# **Sheringham Shoal and Dudgeon Offshore Wind Farm Extension Projects**

**Draft Statement of Common Ground with National  
Highways (Revision D)**

Title:	
<b>Sheringham Shoal and Dudgeon Offshore Wind Farm Extension Projects Draft Statement of Common Ground with National Highways (Revision D)</b>	
PINS Document no.: 12.22	
Document no.: C282-RH-Z-GA-00219	
Revision: D	
Date:	Classification
<b>July 2023</b>	<b>Draft</b>
Prepared by:	
<b>Royal HaskoningDHV</b>	
Approved by:	Date:
<b>Sheery Atkins, Equinor</b>	July 2023

▨ VEHICLE BODY SWEEP PATH (FORWARD GEAR)  
 — VEHICLE CHASSIS SWEEP PATH

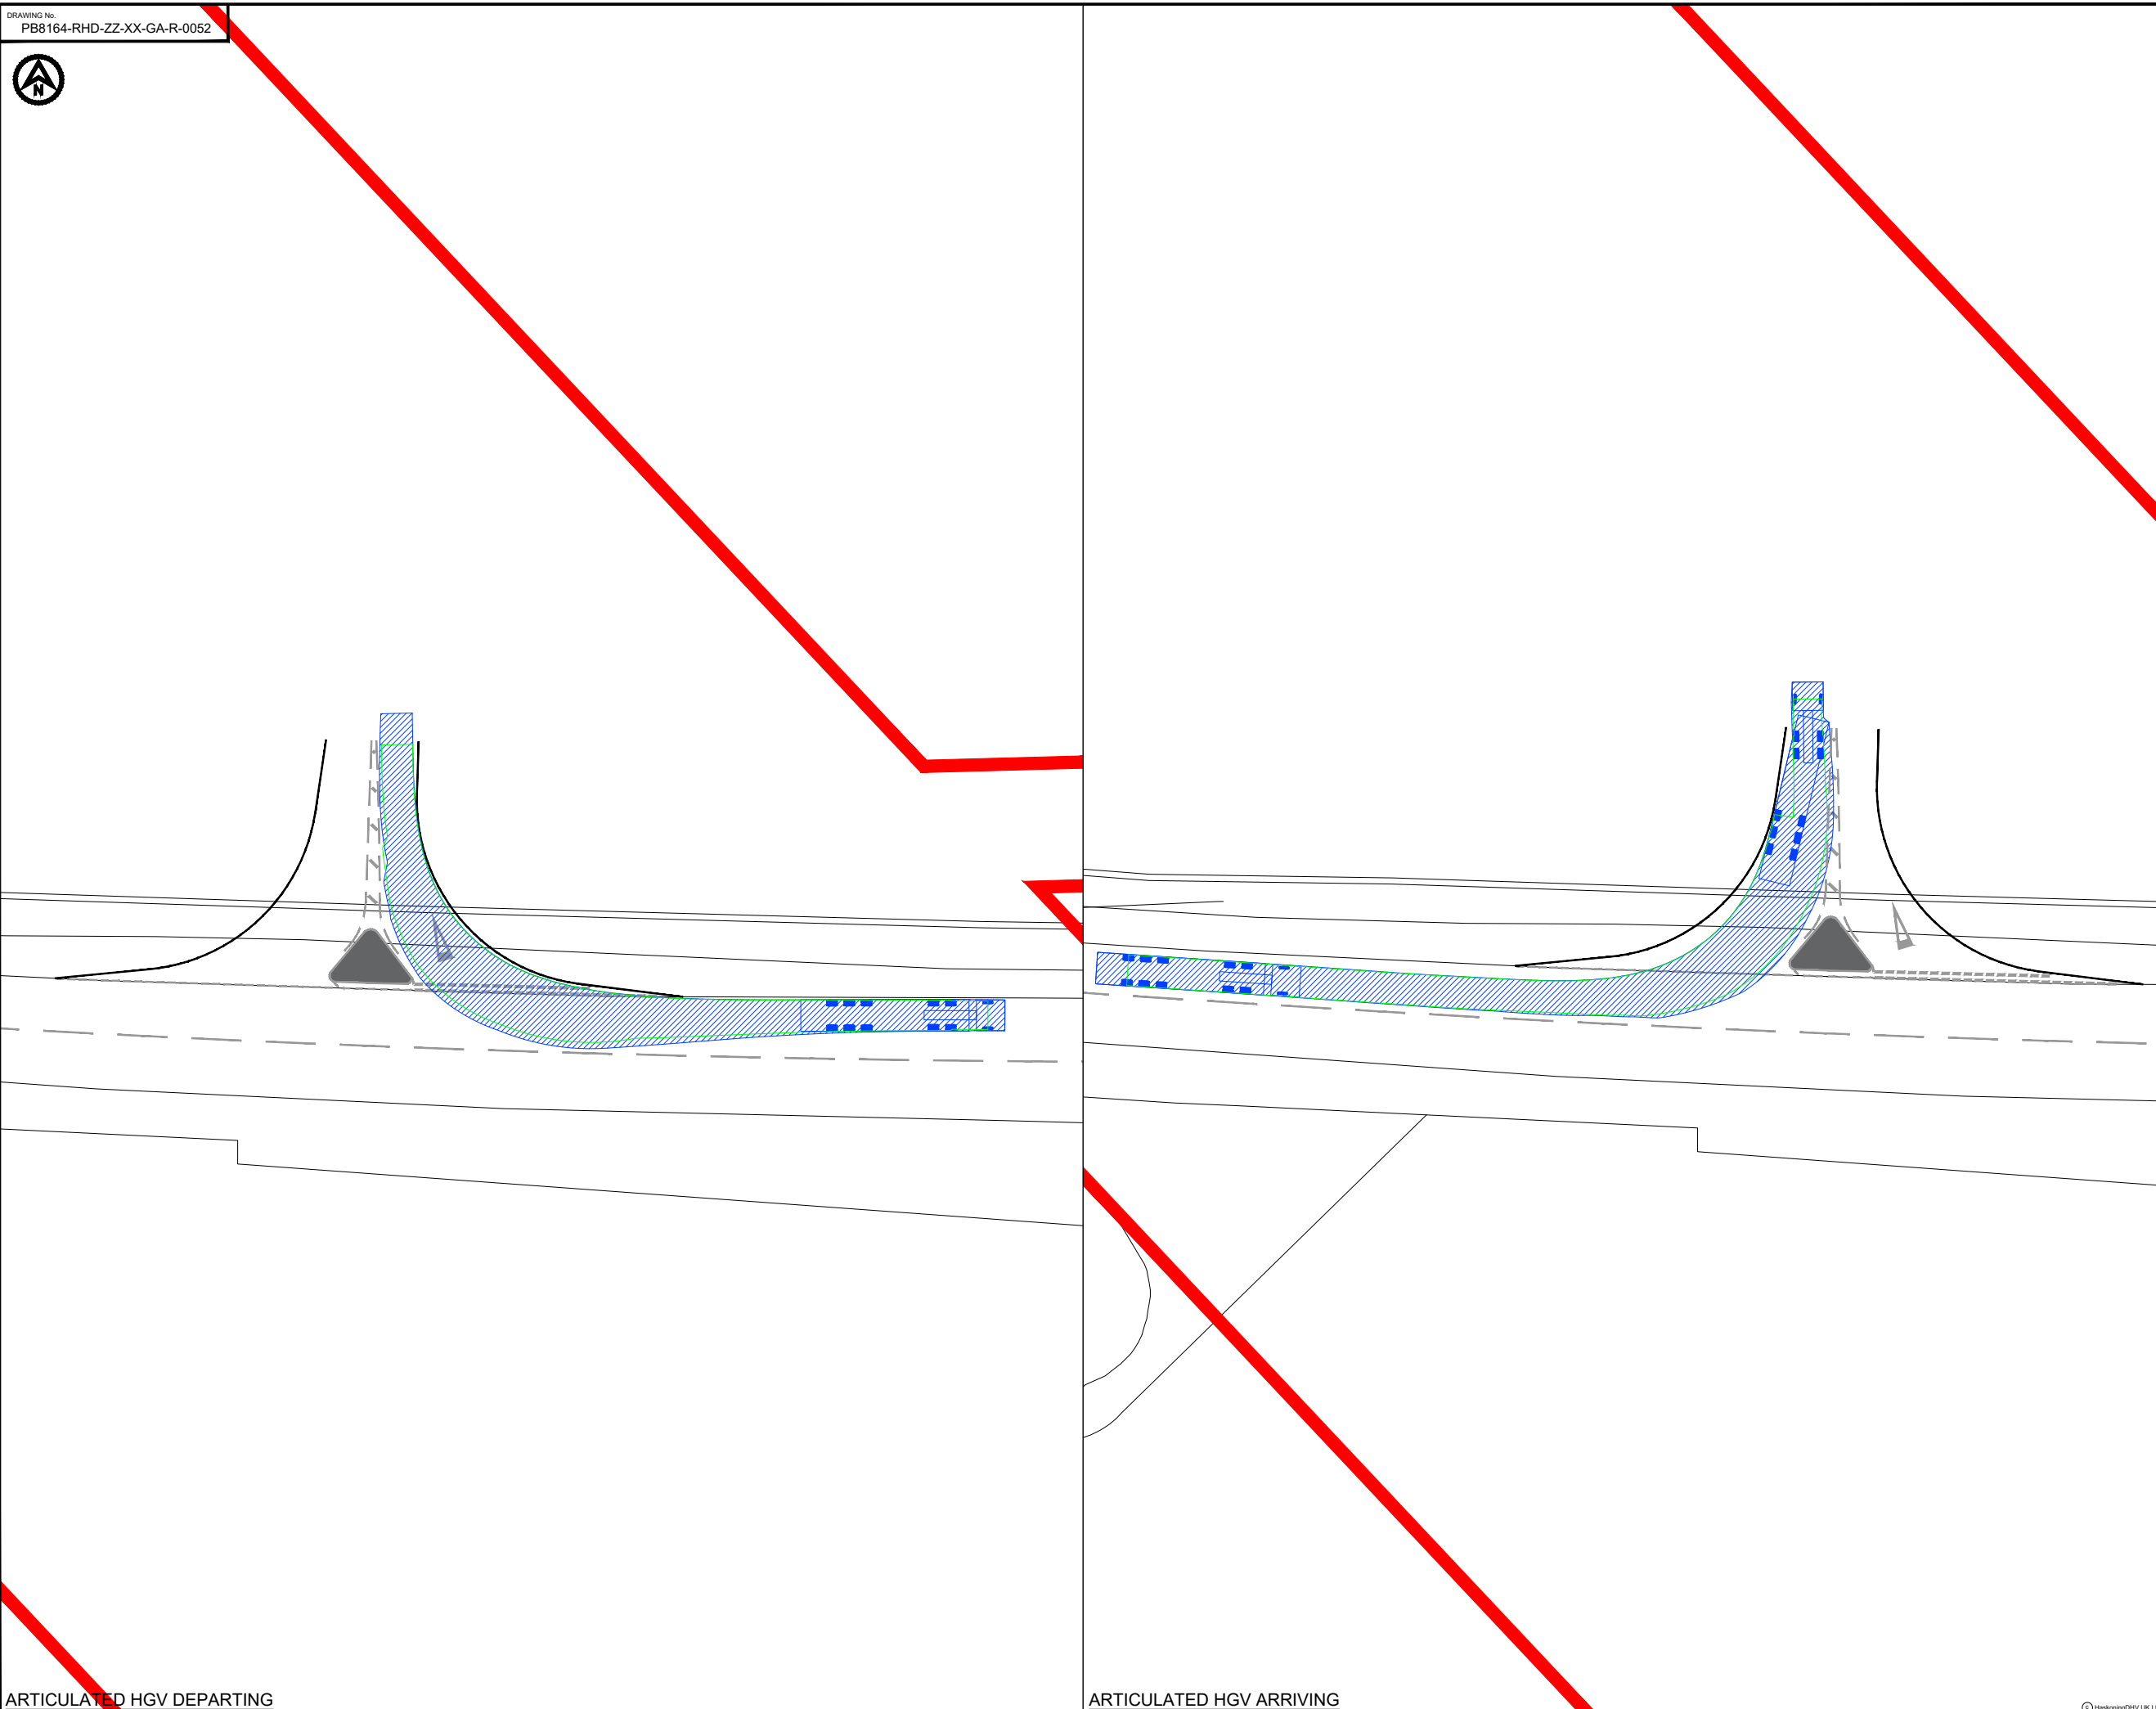
23	The outline design for an access off the A47 is appropriate, as presented in Annex 30 of the Transport Assessment [APP-268 and APP-269]	National Highways agree that the outline design for an access off the A47 (ACC47) is appropriate subject to Stage 1 and 2 Road Safety Audits being carried out post consent. Please note that this access is only usable until the A47 Tuddenham scheme starts construction, or if the A47 Scheme does not go ahead.	<i>Agreed</i>
<b>EIA – Cumulative Impact Assessment (CIA) Conclusions</b>			
24	Cumulative impacts assessment with other windfarms, as presented in Section 24.7 of ES Chapter 24 Traffic and Transport [APP-110], is appropriate based on currently available information and proposed mitigation, impacts are not significant in EIA terms.	National Highways agree that the cumulative impacts assessment with other windfarms, in relation to effects on traffic along the SRN, as presented in Section 24.7 of ES Chapter 24 Traffic and Transport [APP-110], is appropriate based on currently available information and proposed mitigation, impacts are not significant in EIA terms.	<i>Agreed</i>

29	The access concept design for access ACC47 is appropriate and that detailed access designs can be developed and agreed with National Highways prior to the start of construction, secured under Requirement 16 of the draft DCO [AS-009].	National Highways agree that the access concept design for access ACC47 is appropriate, subject to Stage 1 and 2 Road Safety Audits to be carried out post consent, and that detailed designs can be developed and agreed with National Highways	<i>Agreed</i>
